**From:** Planning  
**Subject:** FW: UPLOAD Consultation on planning application 3/2021 0335 Ribble Valley View, Old Langho Road, Langho BB6 8AW

**From:** Paton, Julie <[Julie.Paton@lancashire.gov.uk](mailto:Julie.Paton@lancashire.gov.uk)>  
**Sent:** 2 December 2021 17:10  
**To:** Planning <[planning@ribblevalley.gov.uk](mailto:planning@ribblevalley.gov.uk)>  
**Cc:** Andersen, Linda <[Linda.Andersen@lancashire.gov.uk](mailto:Linda.Andersen@lancashire.gov.uk)>  
**Subject:** RE: Consultation on planning application 3/2021 0335 Ribble Valley View, Old Langho Road, Langho BB6 8AW

Proposed site plan

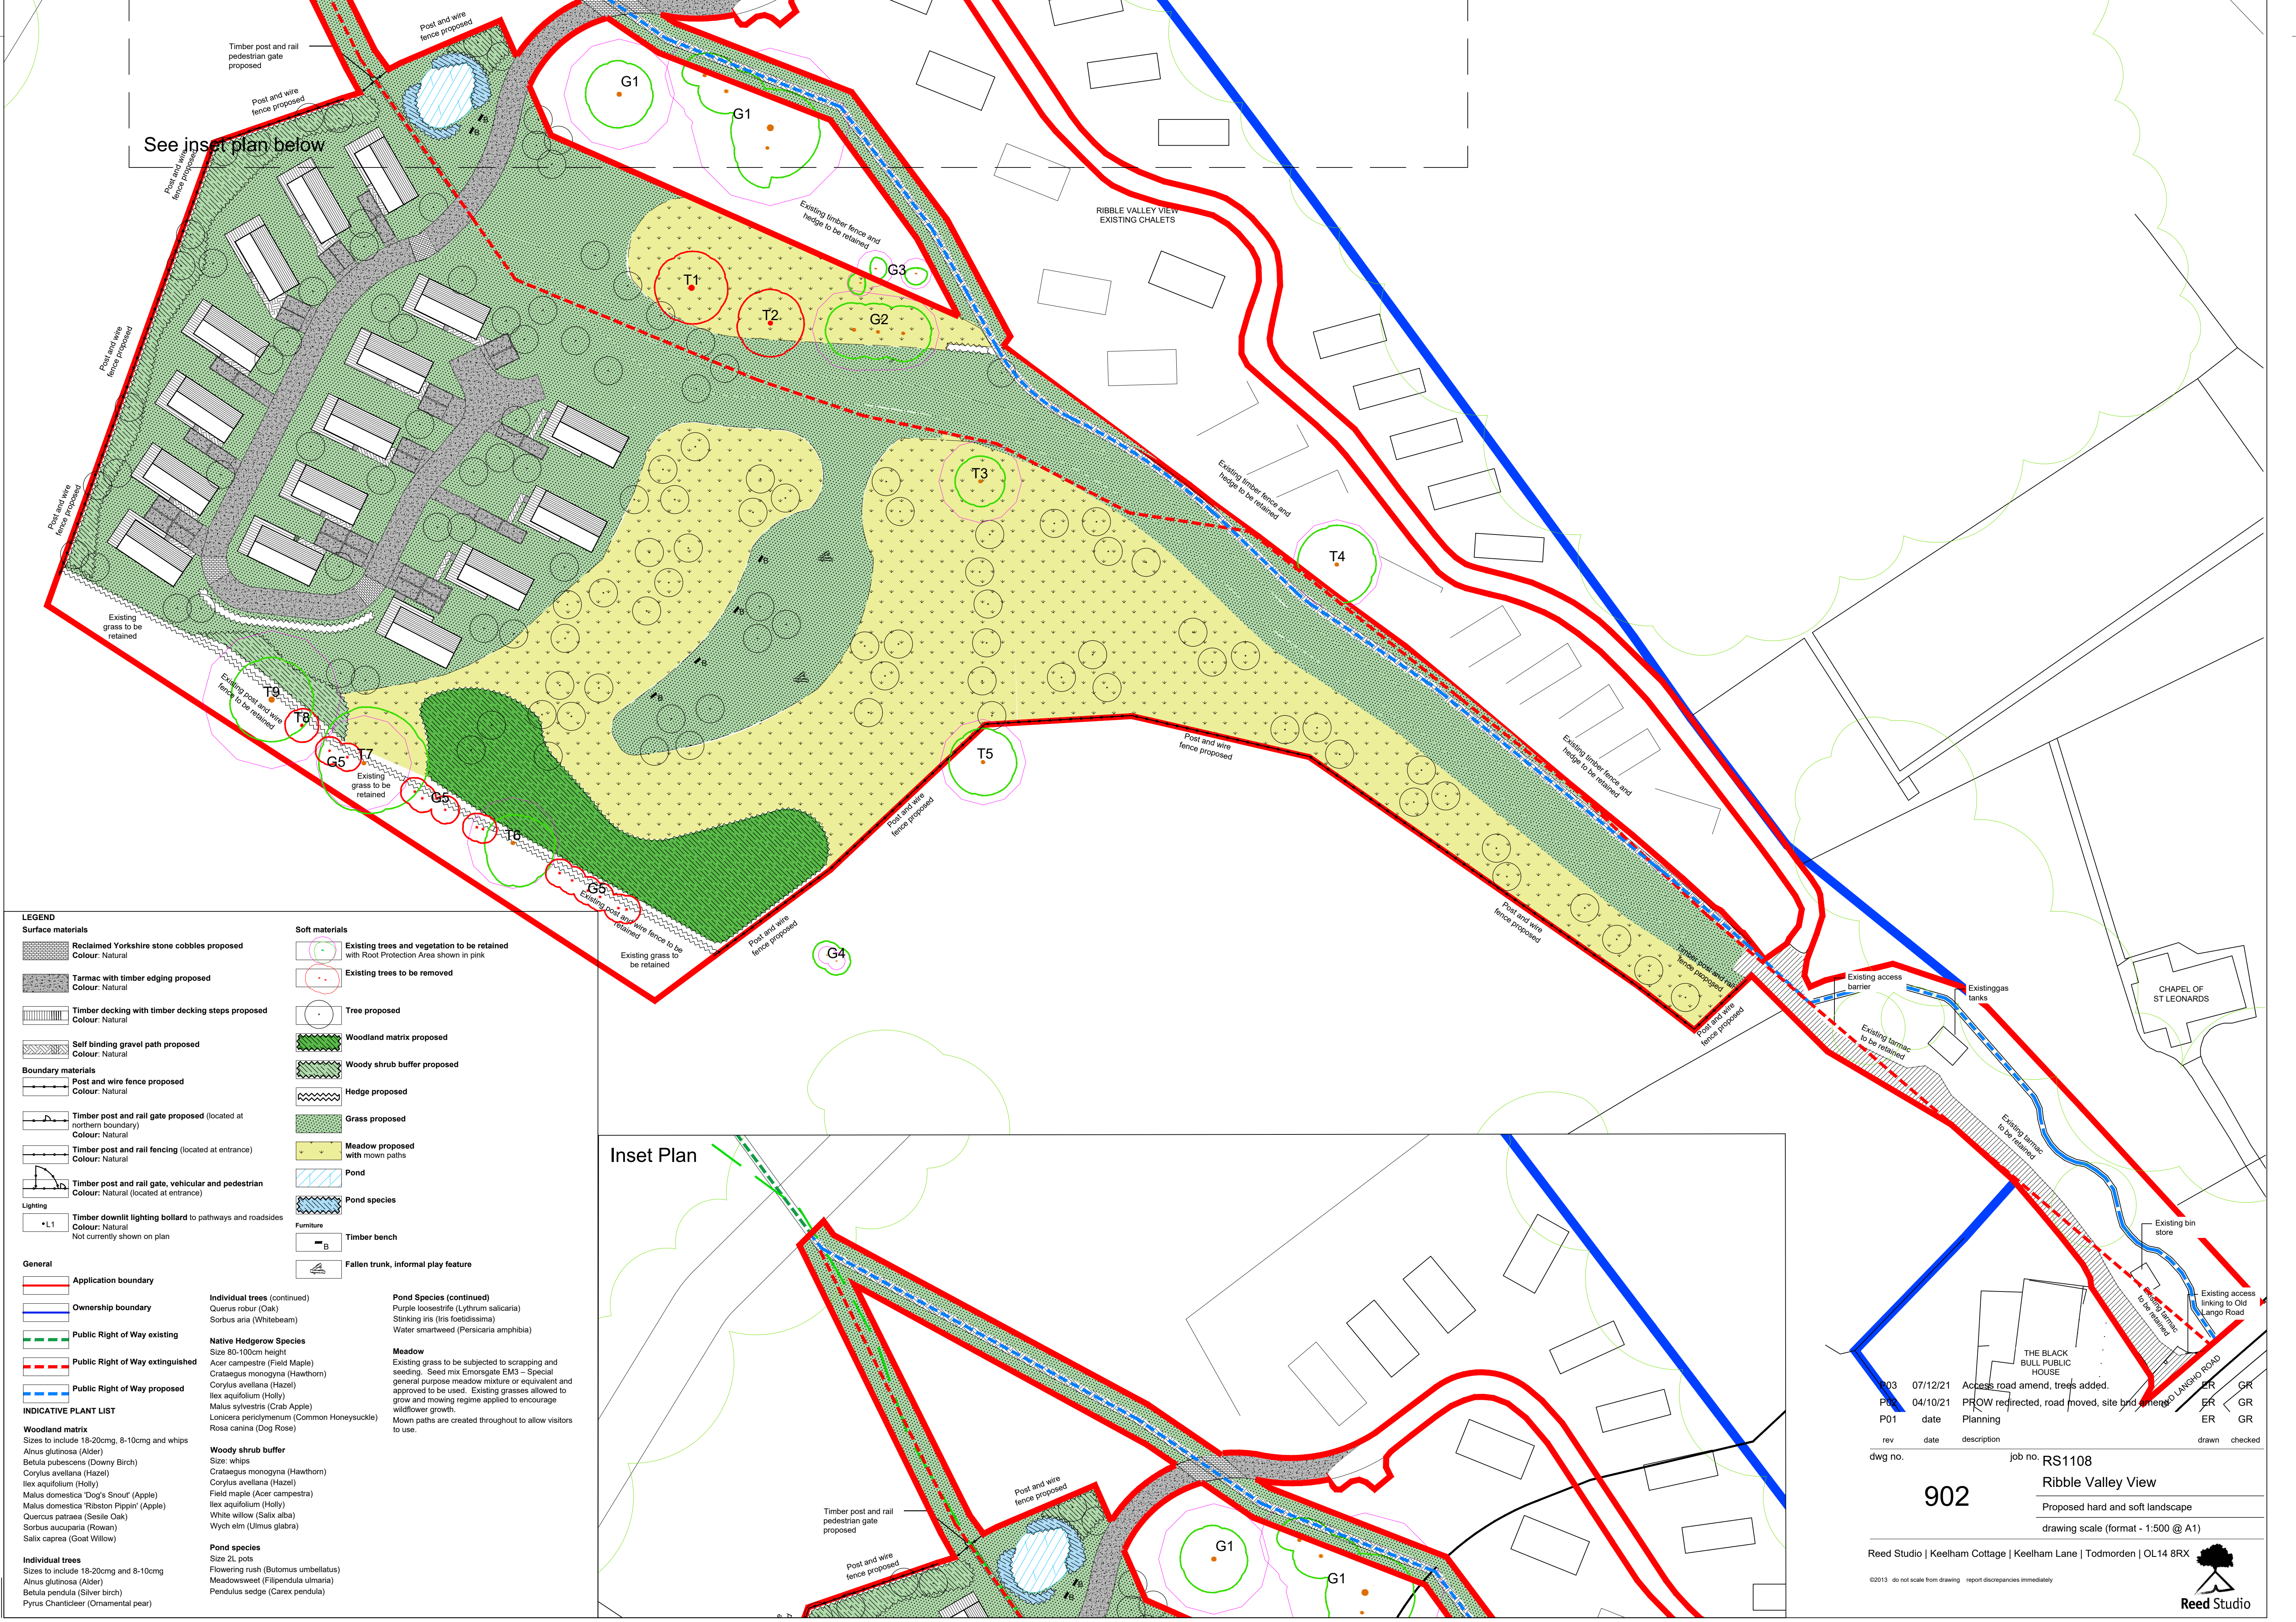
I met with the applicant to discuss the diversion of footpath 3-6-FP5 prior to the resubmission as they wish to divert Footpath 3-6-FP5 between Old Langho Road and Dinkley Brook to provide a segregated footpath all the way through the site, avoiding the curtilage of the new chalets. It is the intention of the applicant to complete the Diversion Order under Section 257 of the Town and Country Planning Act 1990. Lancashire County Council has no objection to the diversion of footpath 3-6-FP5 as detailed in the Design and Access Statement 8Oct21.

It is noted that the revised design and access statement shows the application boundary has been amended to include footpath 3-6-FP5 to the point it crosses Dinkley Brook but omitted to include the land east of the main entrance between Old Langho Road and the entrance to Ribble Valley View Lodges, also within the landownership of the applicant.

If the diversion of footpath 3-6-FP5 between Old Langho Road and the entrance to Ribble Valley View Lodges is excluded from the Section 257 Diversion a separate Diversion request will be necessary to Lancashire County Council.
